24 March 2017

**RE: Australian Technology Park, Eveleigh
Section 96(1A) Application**

General Arrangement Plans 1:250
 Lower Ground

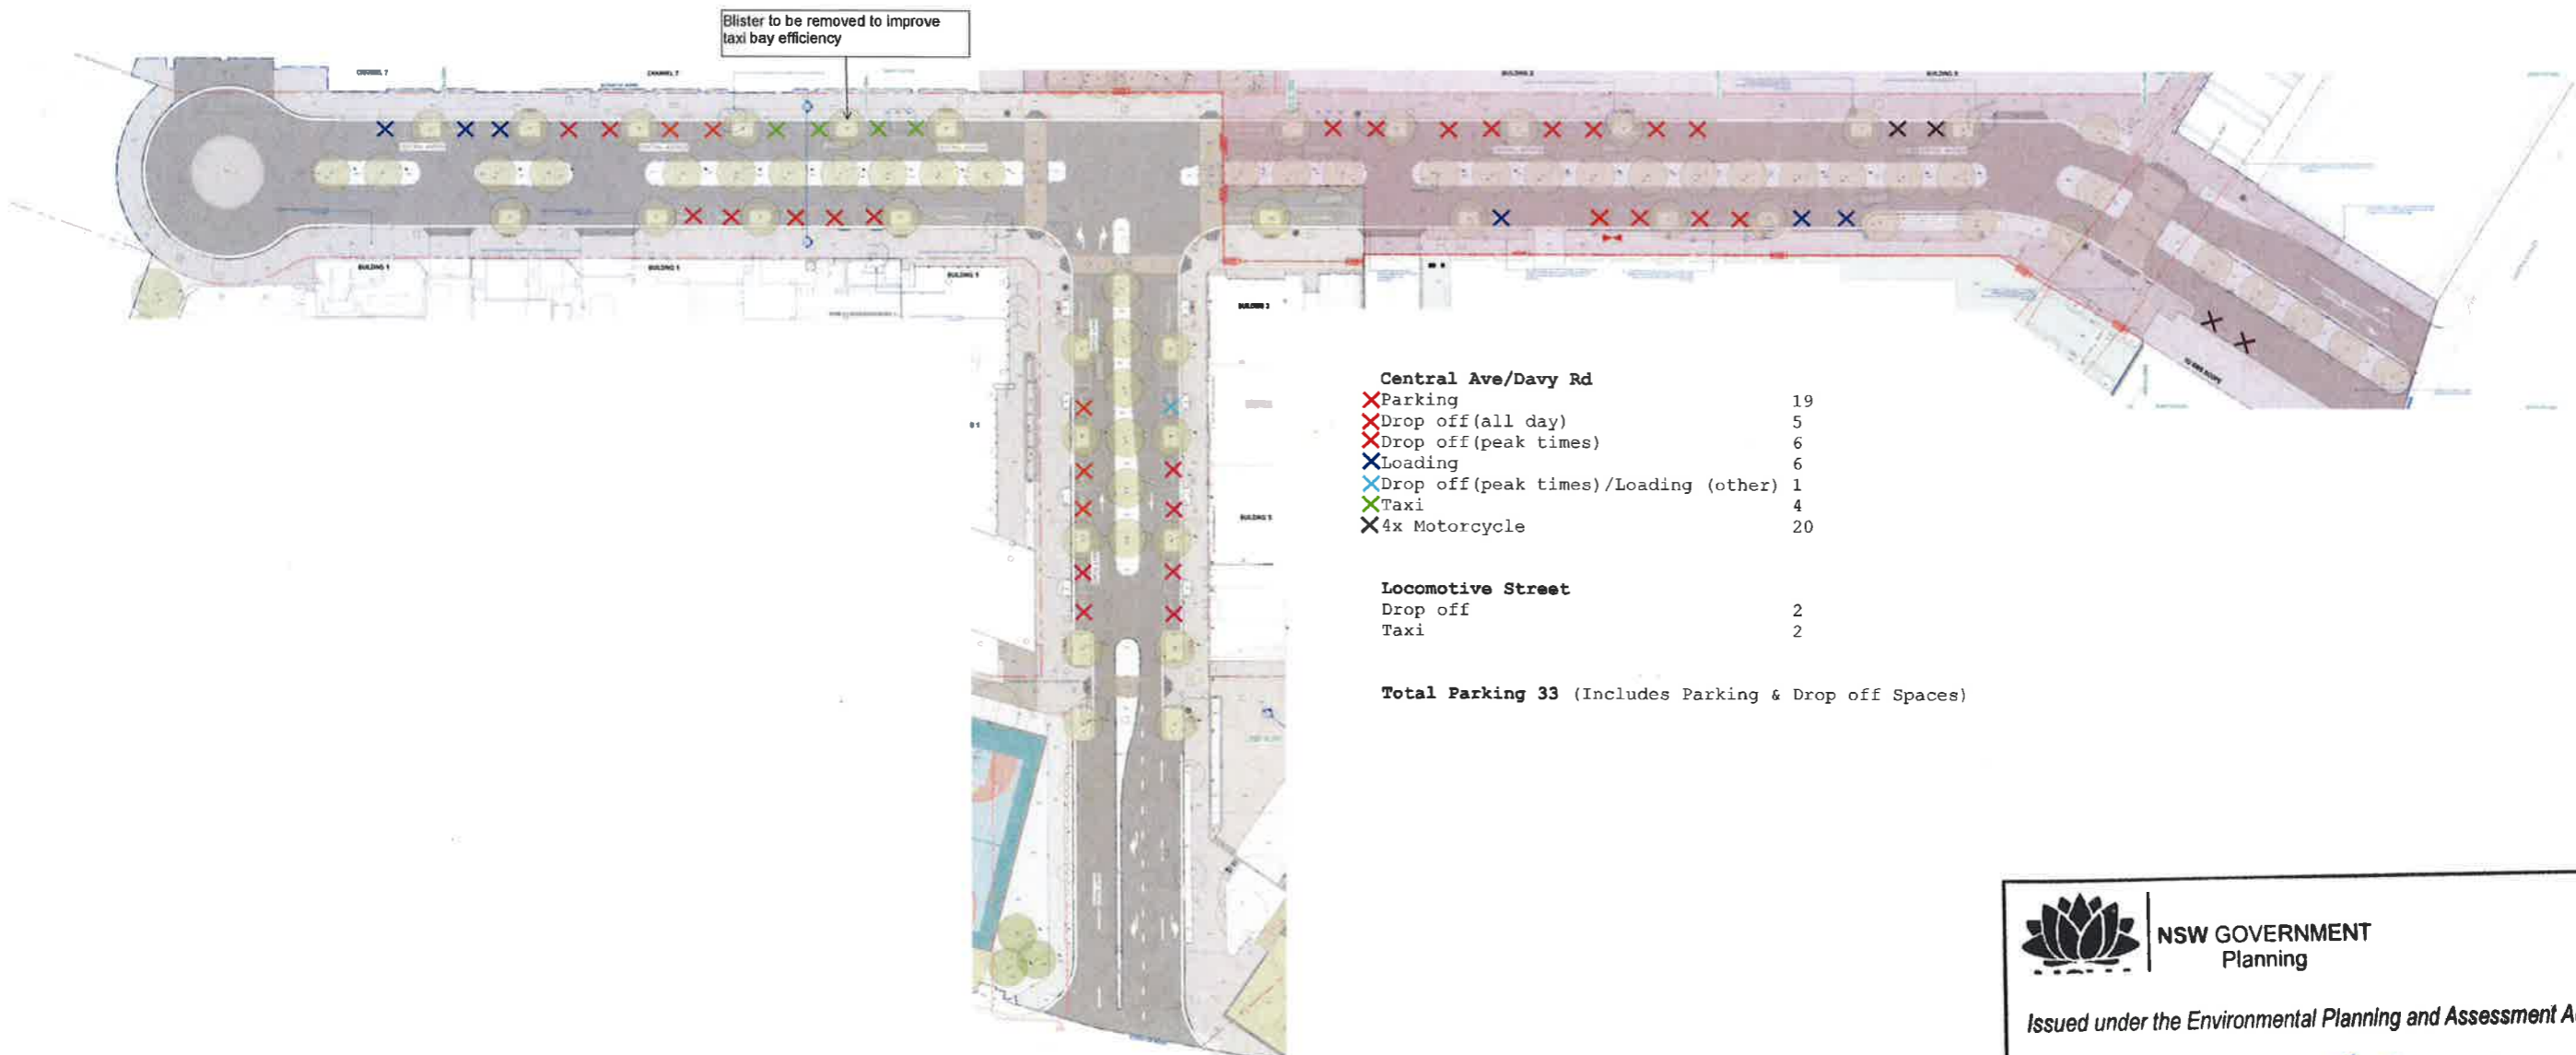
It is proposed to reduce the total number of accessible car parking spaces from 12 to 6, with an overall car parking provision of 500 spaces. We make the following comments:

- The building is understood to include BCA classifications 5 (office, commercial), 6 (retail), and 7a (carpark).
- 100% of the available car parking provision is proposed for the exclusive use of the commercial segment of the building (i.e. retail premises will not be allocated car parking).
- Under the BCA 2016 and Disability (Access to Premises – Buildings) Standards 2010 (Table D3.5), car parking spaces for people with a disability (designed in accordance with AS2890.6) must be provided for class 5 buildings at a minimum rate of 1% of total spaces.
- Accordingly, as the total parking provision is 500 spaces, all of which is allocated to the class 5 segment of the building, the provision of 6 accessible car parking spaces meets the minimum requirements of the BCA and DDA.

To conclude, MGAC have assessed the proposed car parking amendments and can confirm that it is in full accordance with the mandatory requirements of the BCA and DDA.
